## MEMORANDUM

**TO:** Jean Fraser, Planner  
**FROM:** David Senus, P.E. & Ashley Auger, E.I.T.  
**DATE:** October 9, 2013  
**RE:** Munjoy Heights, Preliminary Level III Site Plan Application

- Preliminary Level III Site Plan Application and attachments dated September 27, 2013, prepared by Redfern Properties, LLC.
- Preliminary Boundary Survey, dated August 9, 2013, prepared by Nadeau Land Surveys on behalf of Redfern Properties, LLC.
- Engineering Plans, Sheets C-01, C-02, C-10, C-20, C-30, C-31, C-32, and C-33, dated September 24, 2013, prepared by Acorn Engineering, Inc. on behalf of Redfern Properties, LLC.

UNDERDRAINED SUB-SURFACE SAND FILTER
TYPICAL CROSS SECTION
NOT TO SCALE

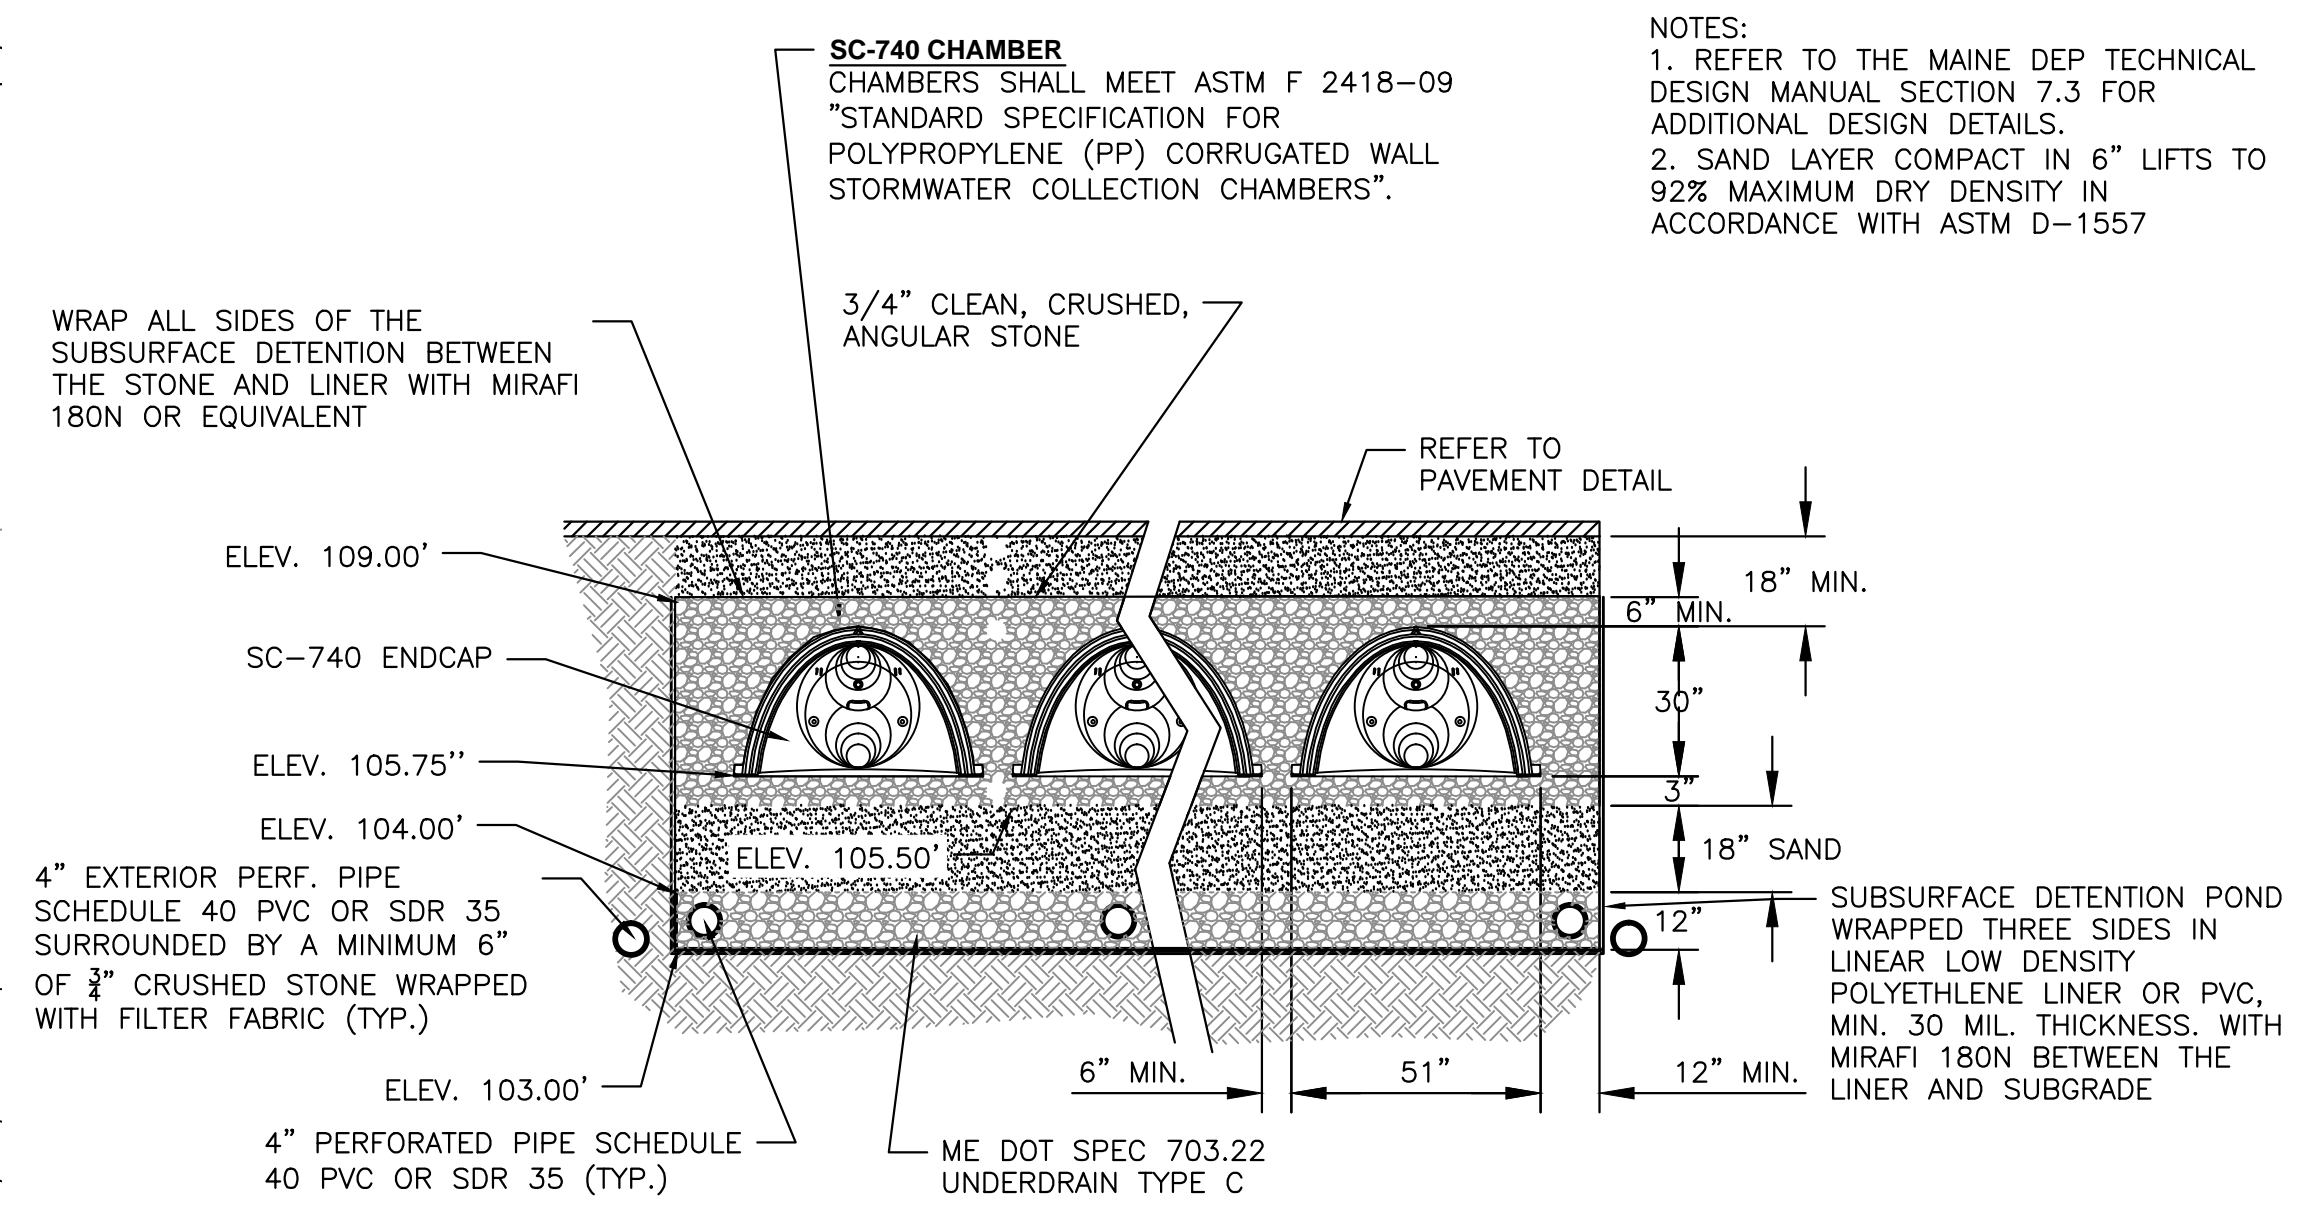
- b) General Standards: The project will result in a net increase in impervious area of approximately 32,879 square feet. As such, the project is required to provide stormwater management features for stormwater quality treatment. The Applicant has noted that the intent is to provide an Underdrained Subsurface Sand Filter BMP to provide treatment for no less than 95% of the new impervious area, and 80% of the developed area. We anticipated that additional notes, details and calculations will be provided to allow us to review the design of this system. In addition, the subsurface stormwater management system is proposed on a steep fill slope; as such, the geotechnical engineer should provide a review of the system design relative to potential impacts on slope stability, foundation drainage, and potential for break-out of infiltrated stormwater on the downhill side of the system.
